3 Application No.: 09DRB-70113	Project # 1007671
	ect Name: La Mesa Subdivision	
Age	nt: Bohannan Huston Inc.	Phone No.:
TOIIO	r request was approved on <u>3-25</u> wing departments. FSTANDING SIGNATURES COMN	by the DRB with delegation of signature(s) to the lents to be delegation of signature.
	TRANSPORTATION: Provide Providents	to letter from Transet Stating their ashibit defining it
		PRESENCED OF WATERLINE
	CITY ENGINEER / AMAFCA:	
	PARKS / CIP:	
	PLANNING (Last to sign):	5 day appeal poriod
	-The original plat and a mylar -Tax certificate from the Count-Recording fee (checks payab-Tax printout from the County	ole to the County Clerk). RECORDED DATE: Assessor. ed site plan. Include all pages. pnature must be obtained prior to the recording of the plat s signature must be obtained prior to Planning e. Il required.

Project# 1007671

09DRB-70083 VACATION OF PUBLIC RIGHT-OF-WAY 09DRB-70113 MINOR - PRELIMINARY/ FINAL PLAT APPROVAL

BOHANNAN HUSTON INC agent(s) for ARMSTRONG DEVELOPMENT PROPERTIES, INC request(s) the above action(s) for all or a portion of Lot(s) 1-13, 34 & 35, Block(s) 1, Tract(s) A & B, LA MESA SUBDIVISION zoned C-2, located on CENTRAL AVE BETWEEN LOUISIANA BLVD A

PLAT OF  
TRACT A-1, BLOCK 1  
LA MESA

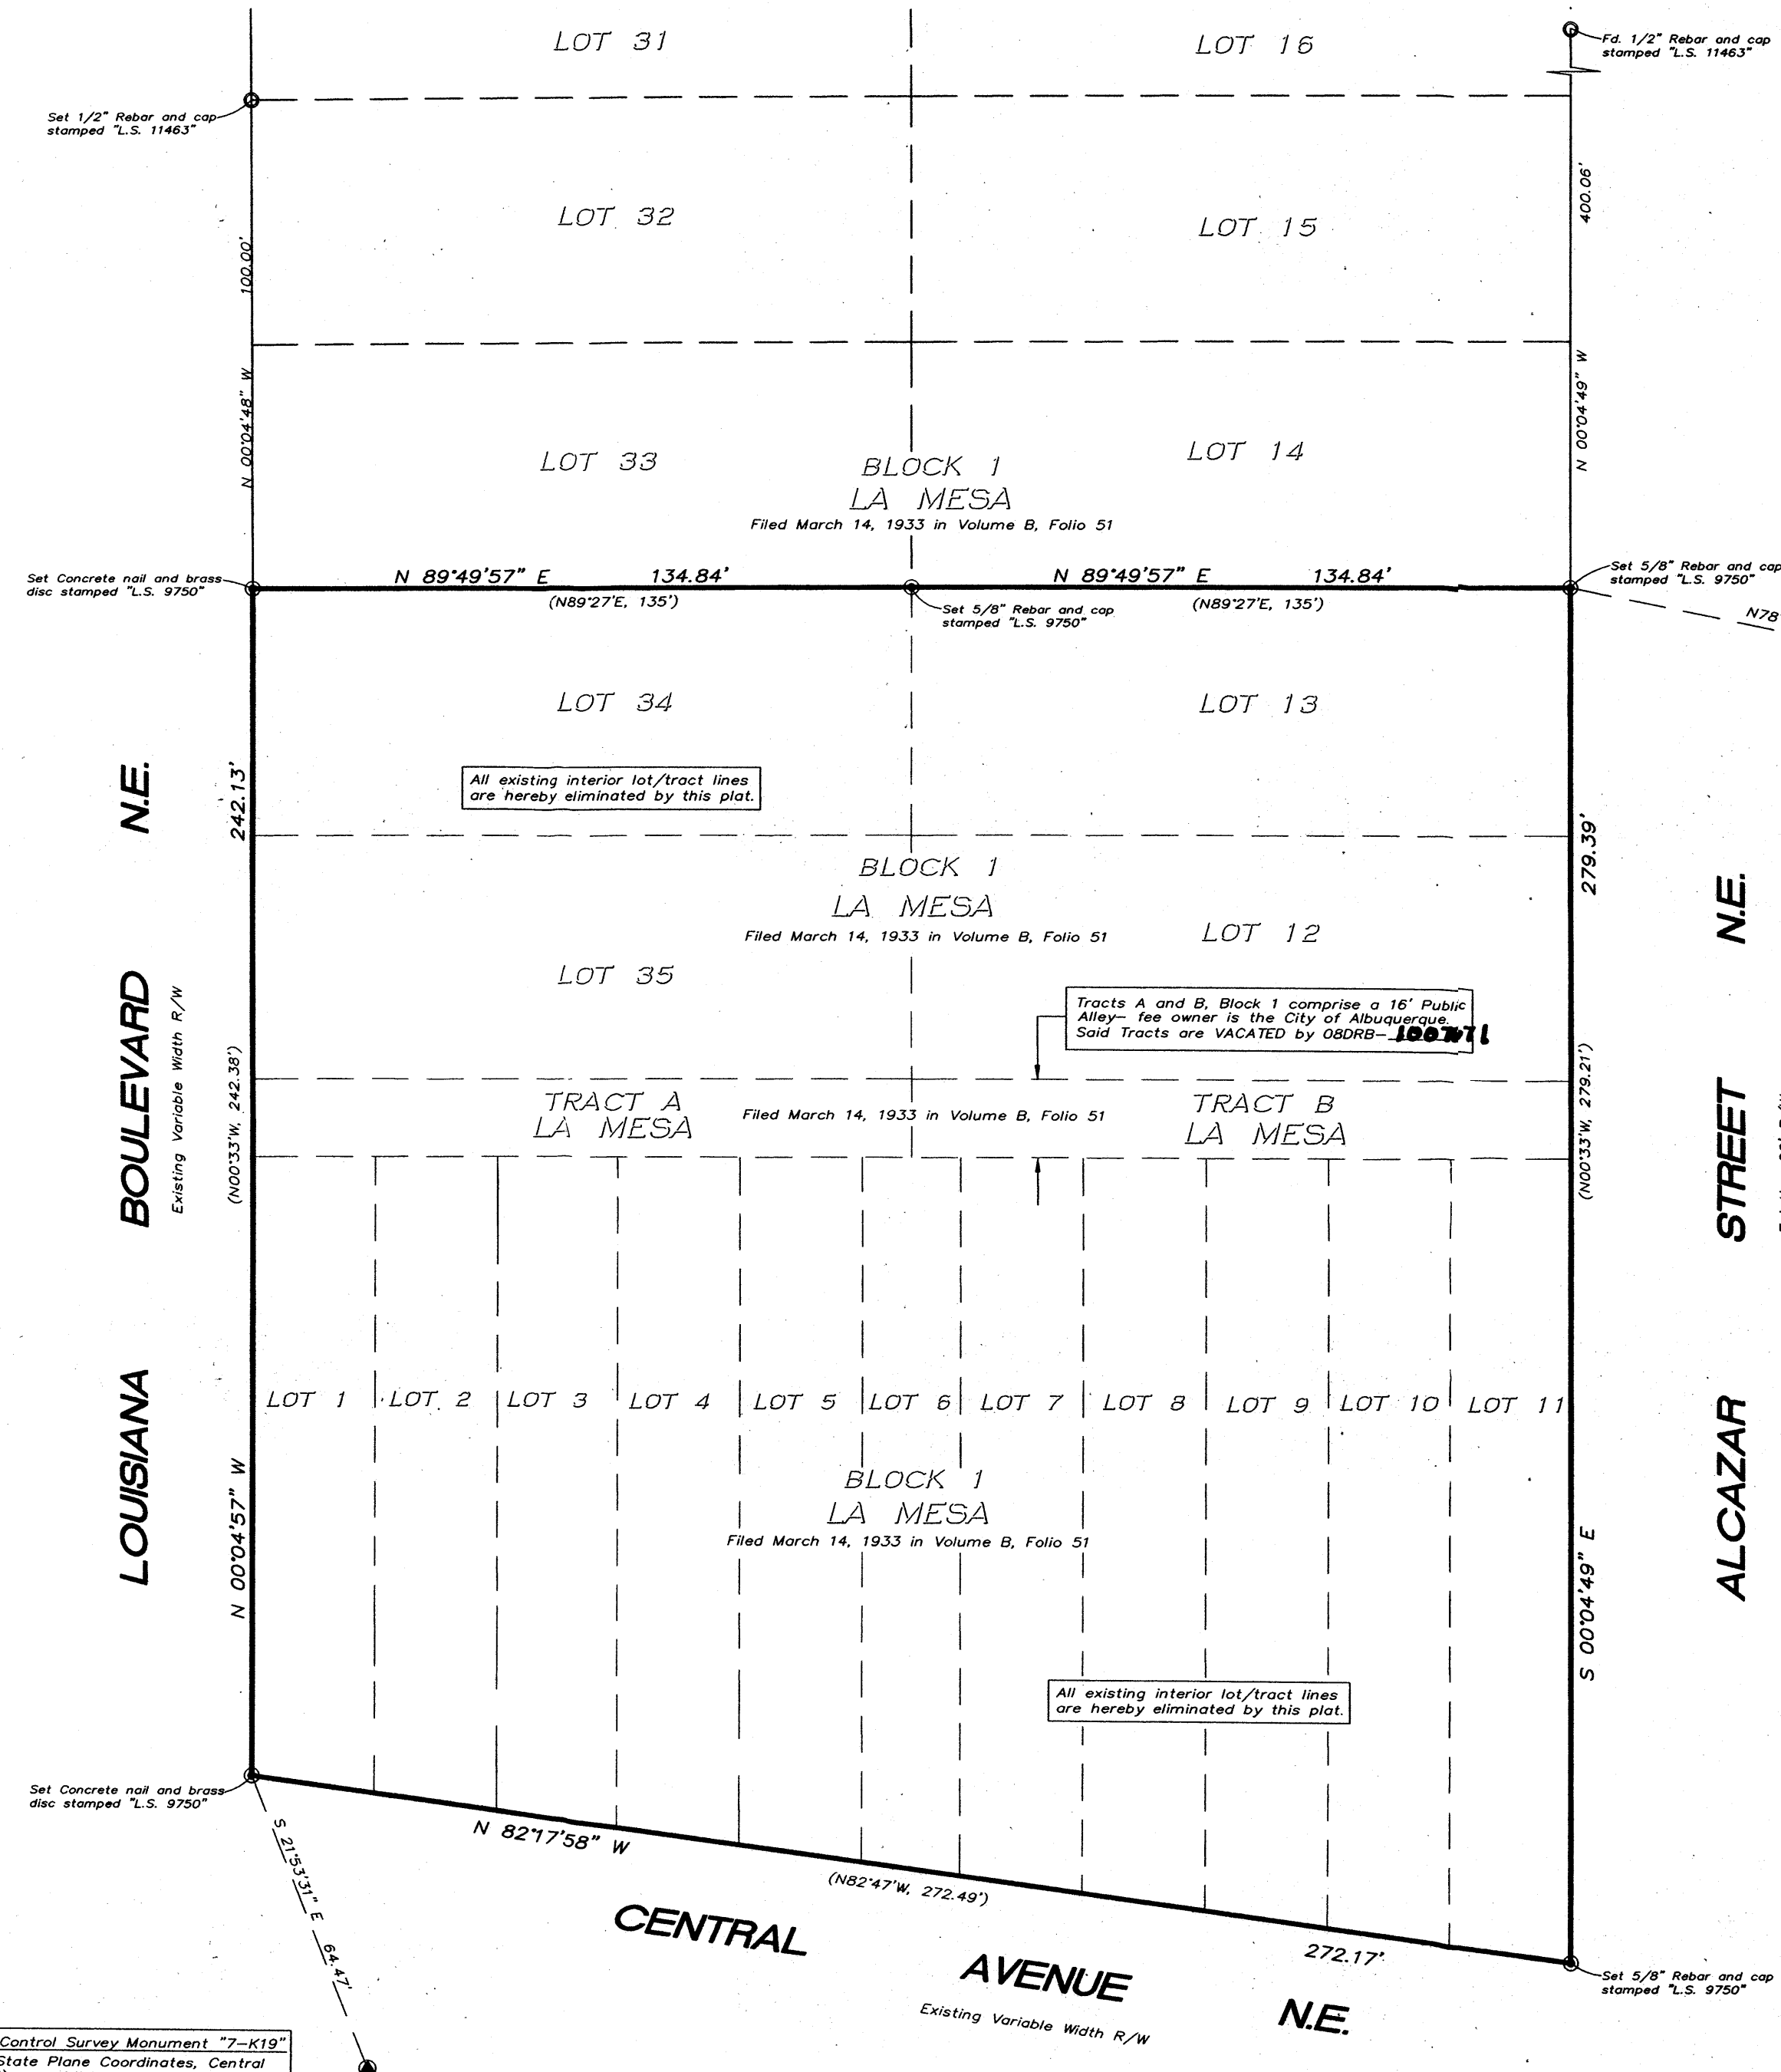
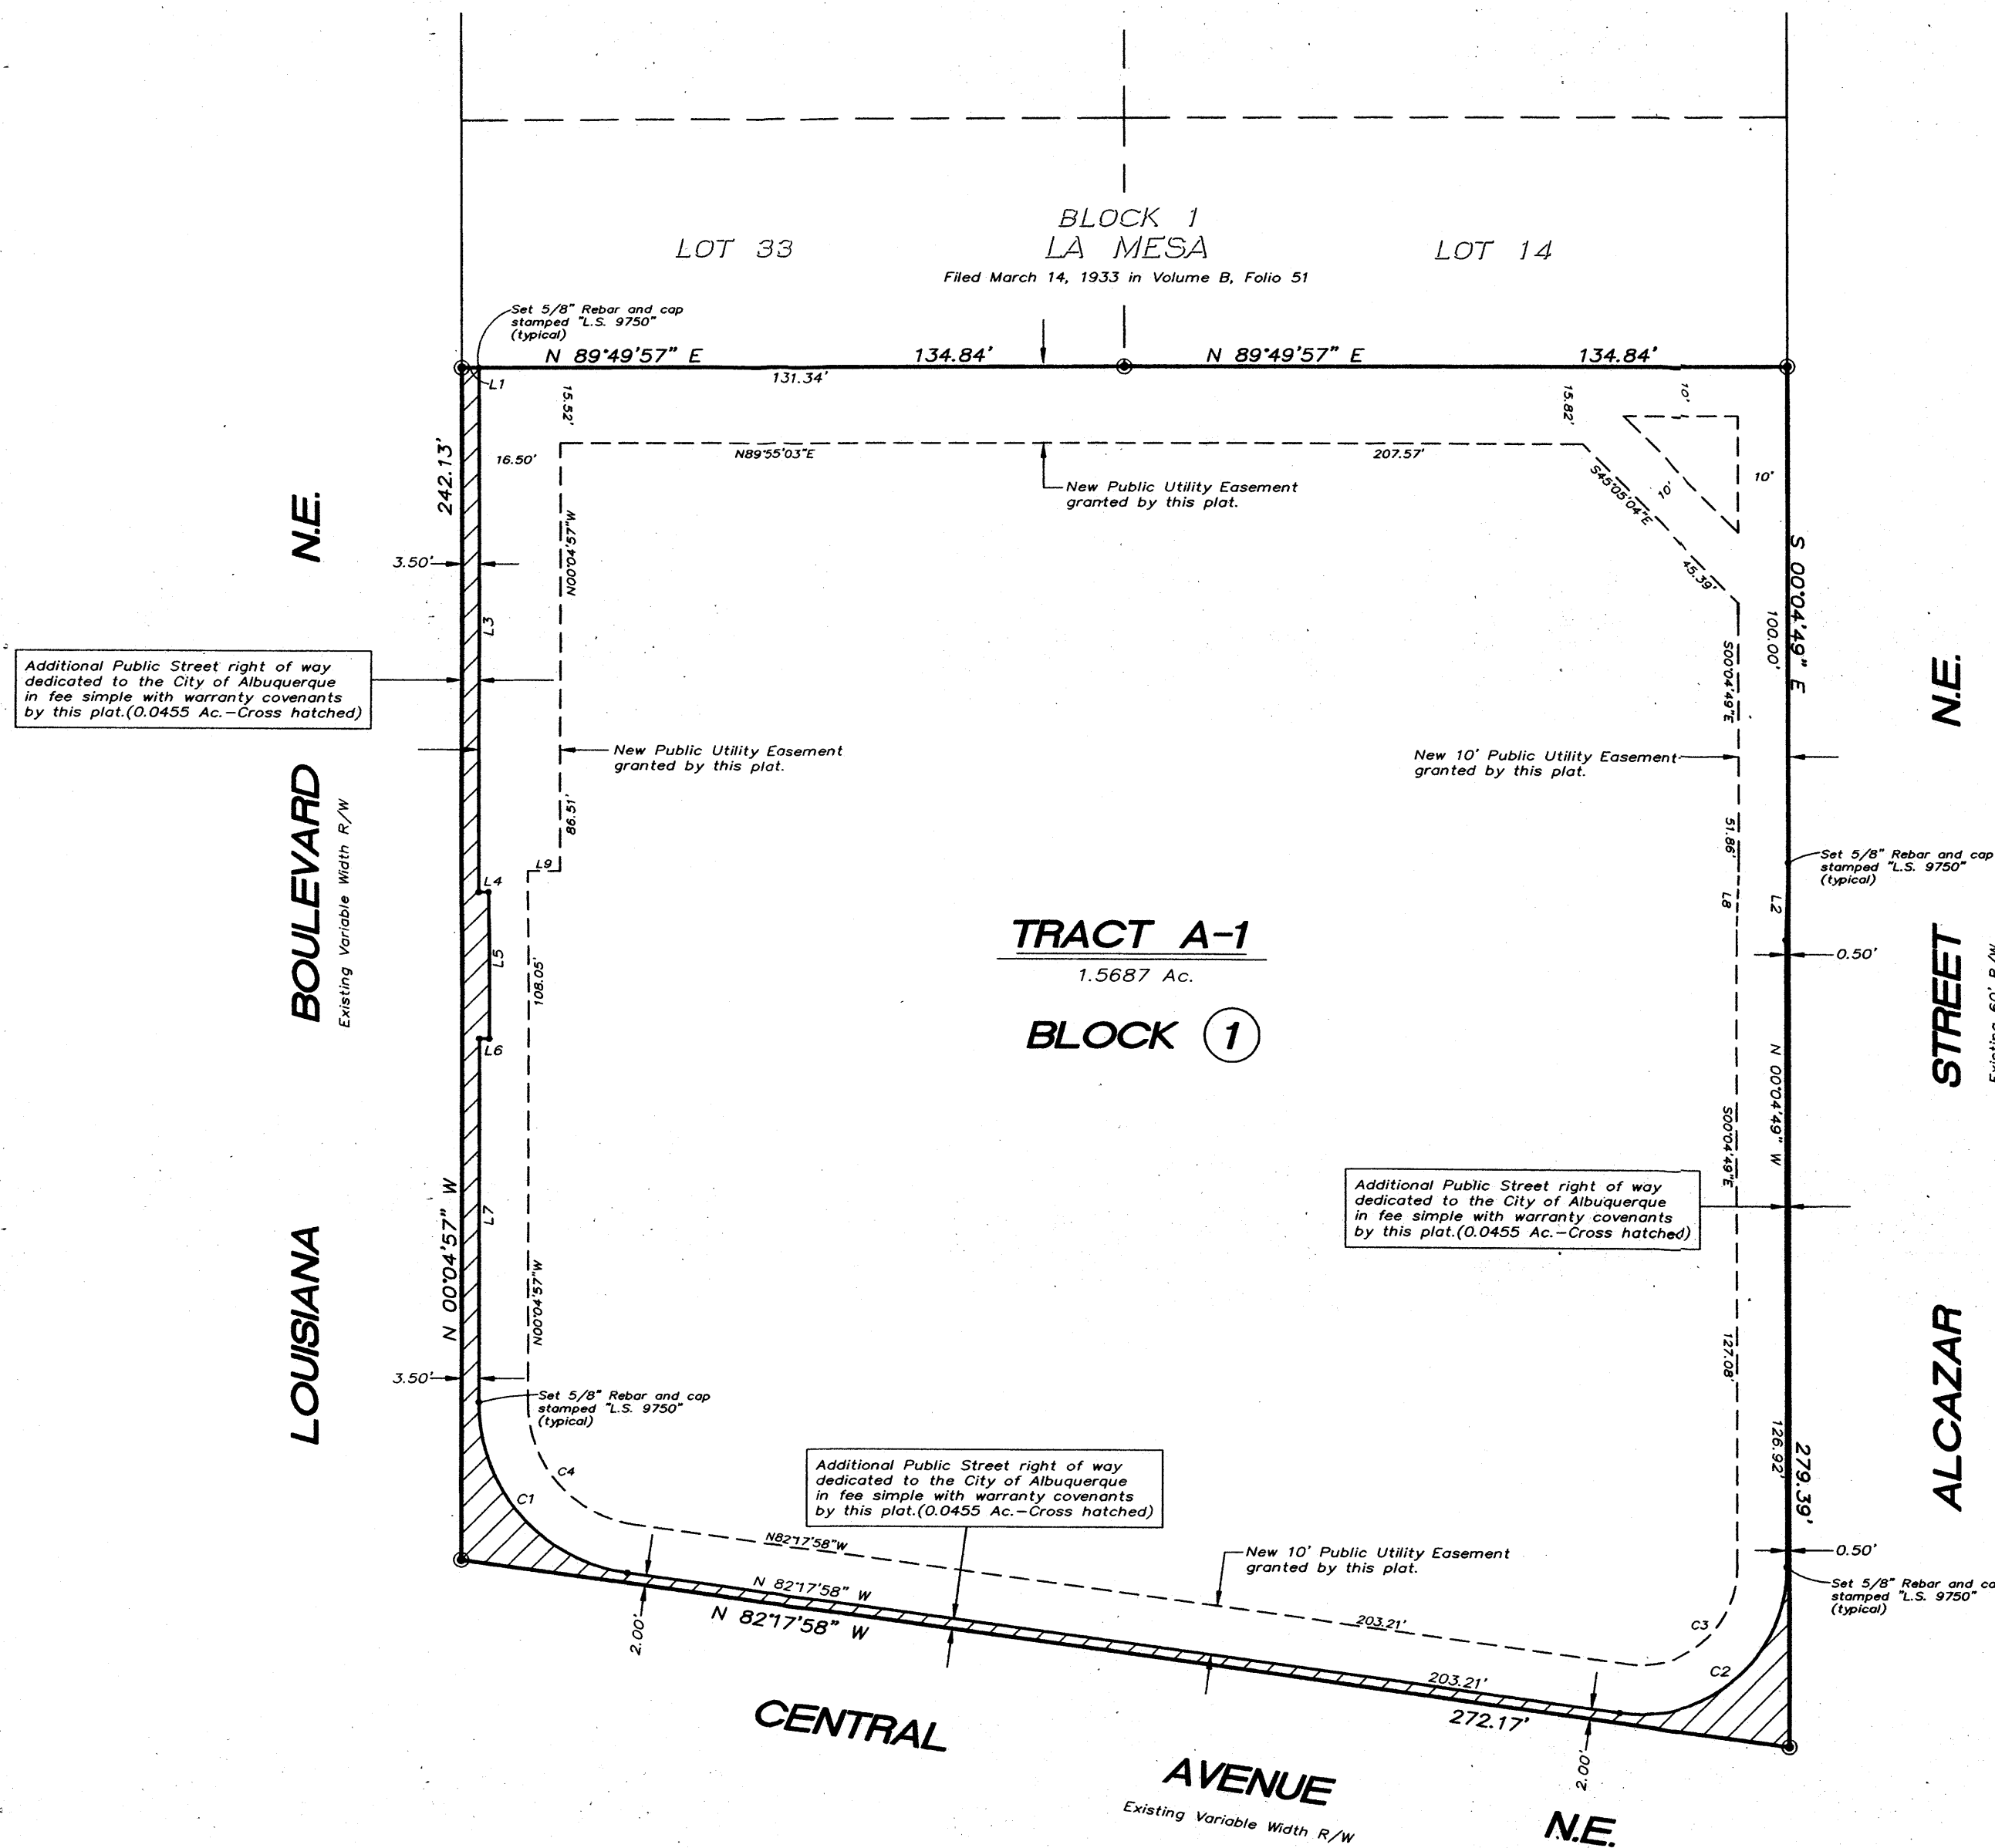
Concerning the subject case number(s), Qwest has no objection to the vacation provided a PUE is granted for the existing poles and aerial cable in the alley. Prior to any final plat approval, we will need a copy for review.

Condition of final plat: appropriate cross access or lot consolidation will be required.
